Scott Harvey
2933 Tram Rd.
Fuquay Varina, NC 27501
RE: Harvey John's Steakhouse

A plan review was received by this office concerning the construction of the above referenced facility. Additional information is needed for the review to continue:

**FS-100**

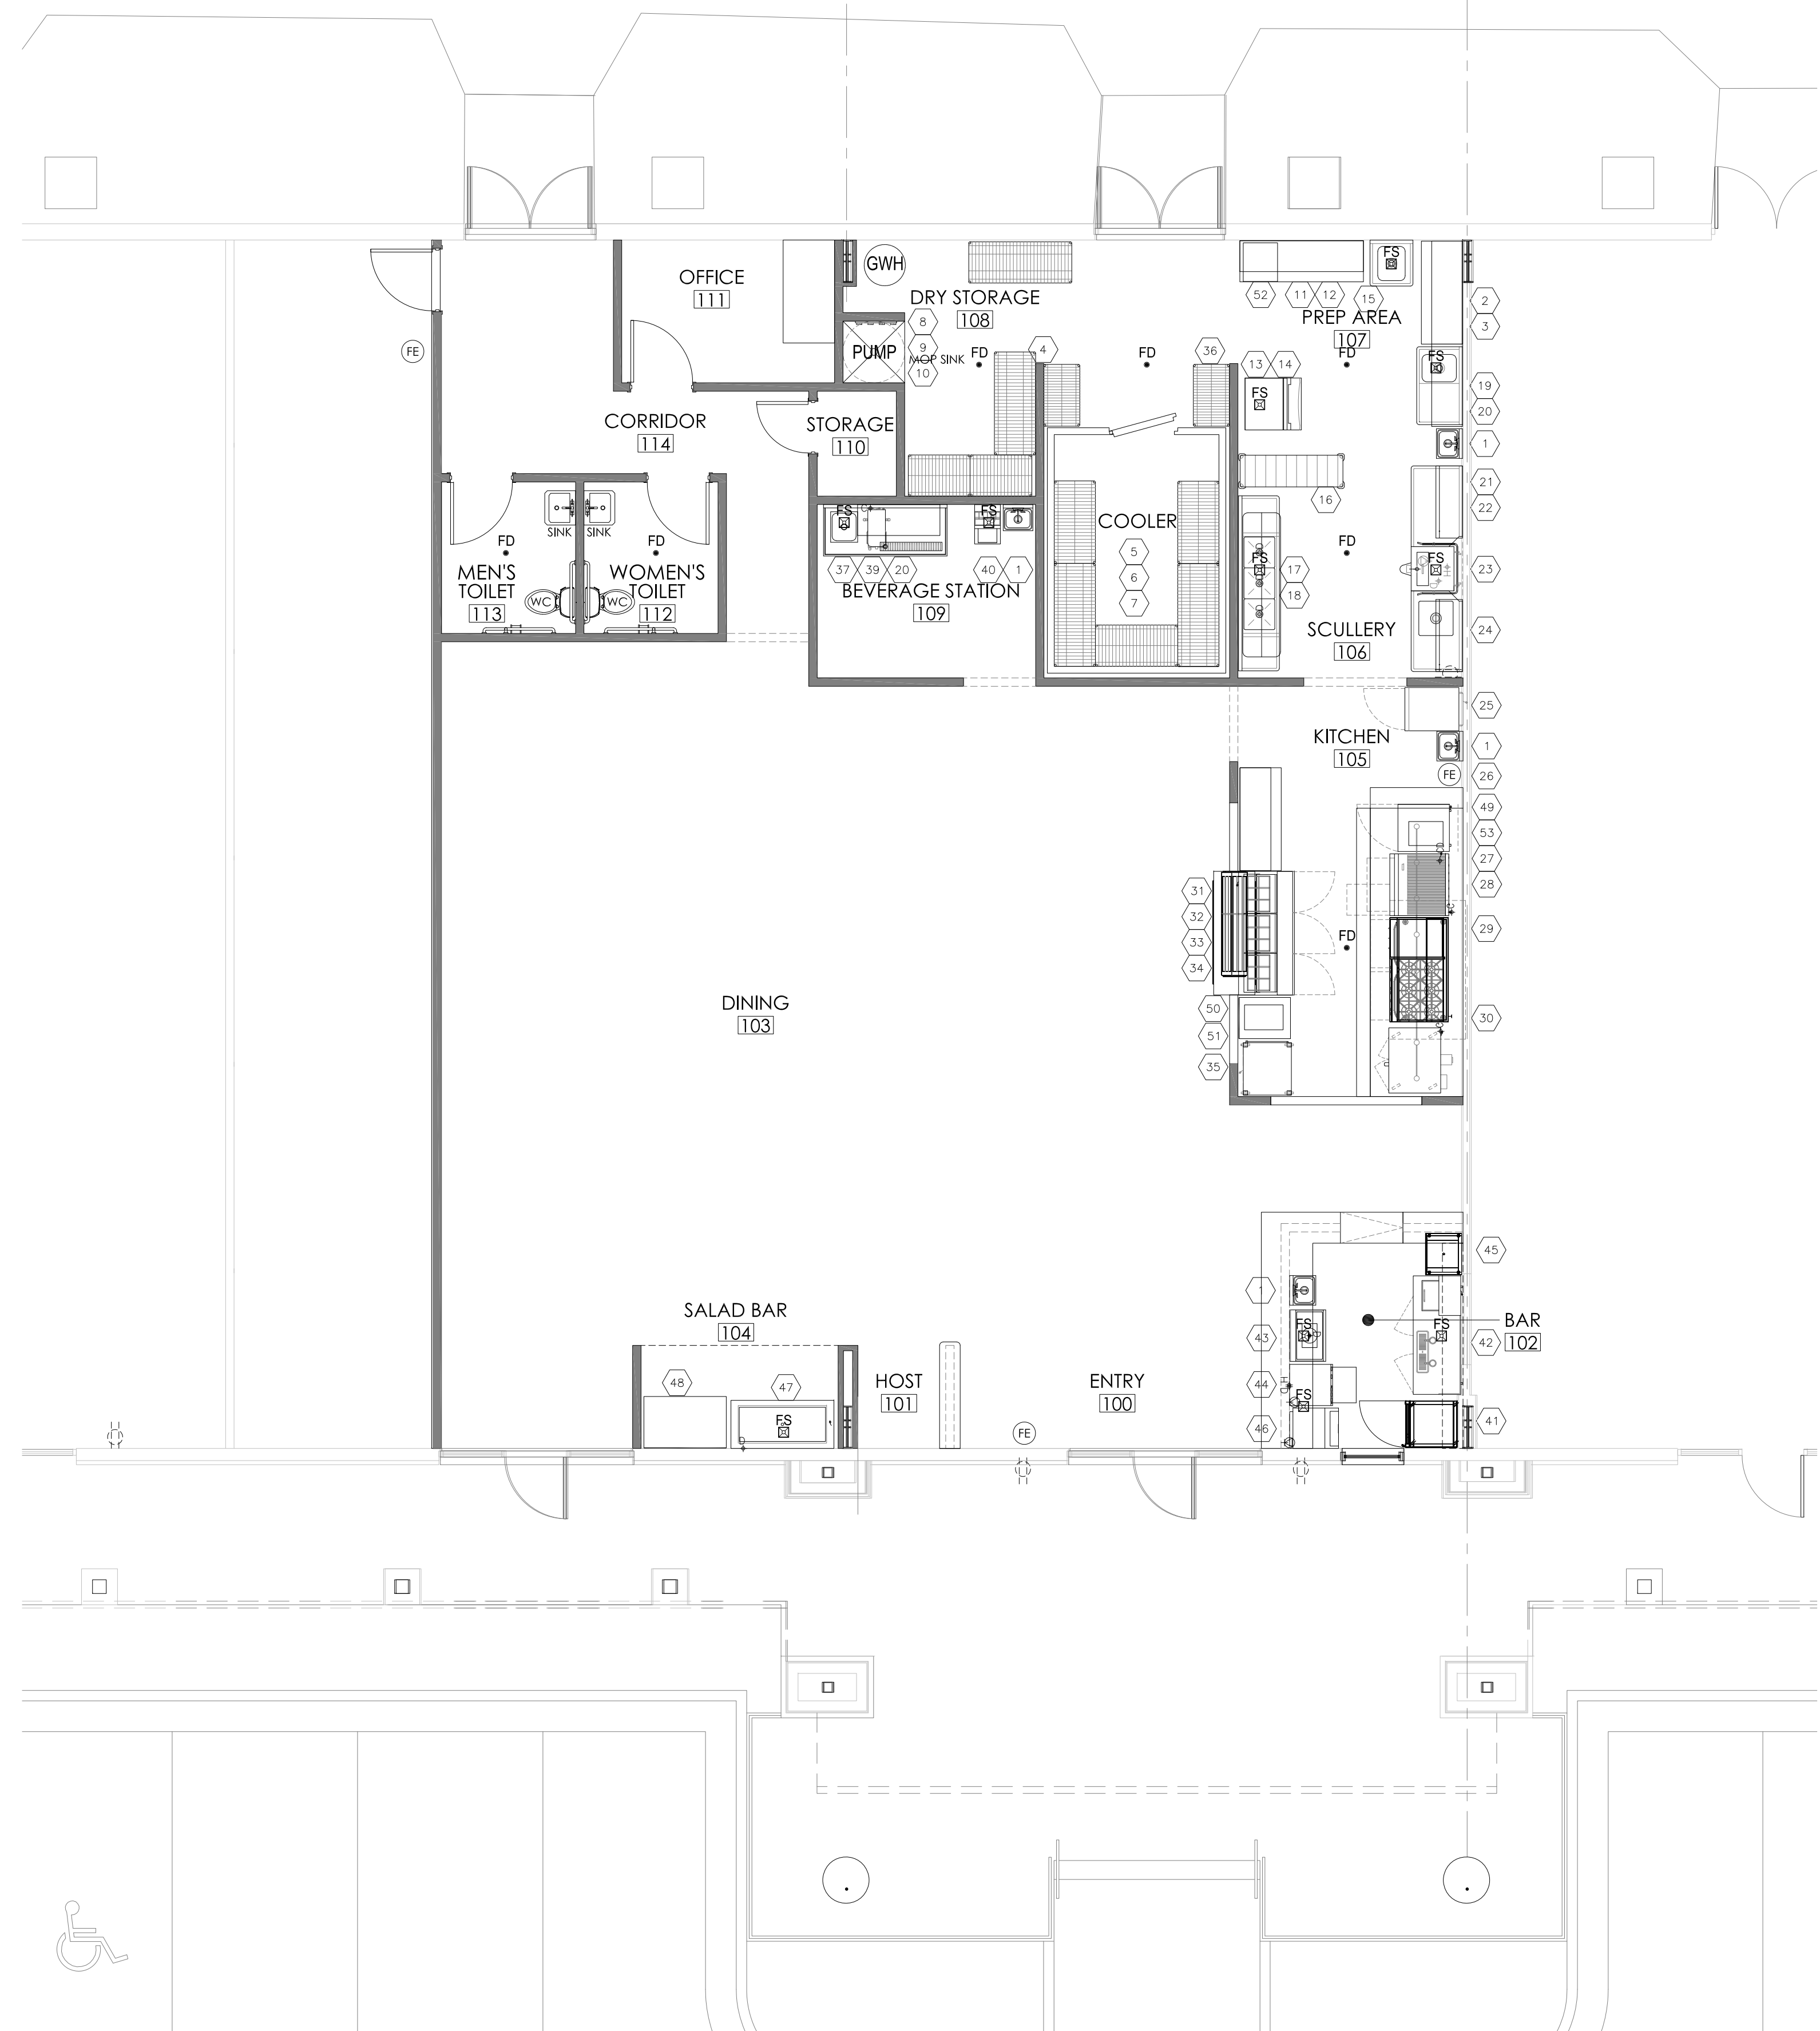
- Indicate location of tabletop equipment such as ROP machine, sous vide machine etc on plans.
- The only hot holding equipment specified is a cabinet. Where will items such as bone marrow gravy, compound butter or sides be held? Will there be hot holding wells and if so where will they be located?

- No information or description of ROP and sous vide volume, procedures and frequency provided.
- Indicate intended use for millwork table located next to salad buffet unit.

- Indicate proposed use of tables placed near prep sinks. One compartment meat sink is effectively blocking the left side of the table placed next to the vegetable sink. Splashguards would make this area difficult to use.
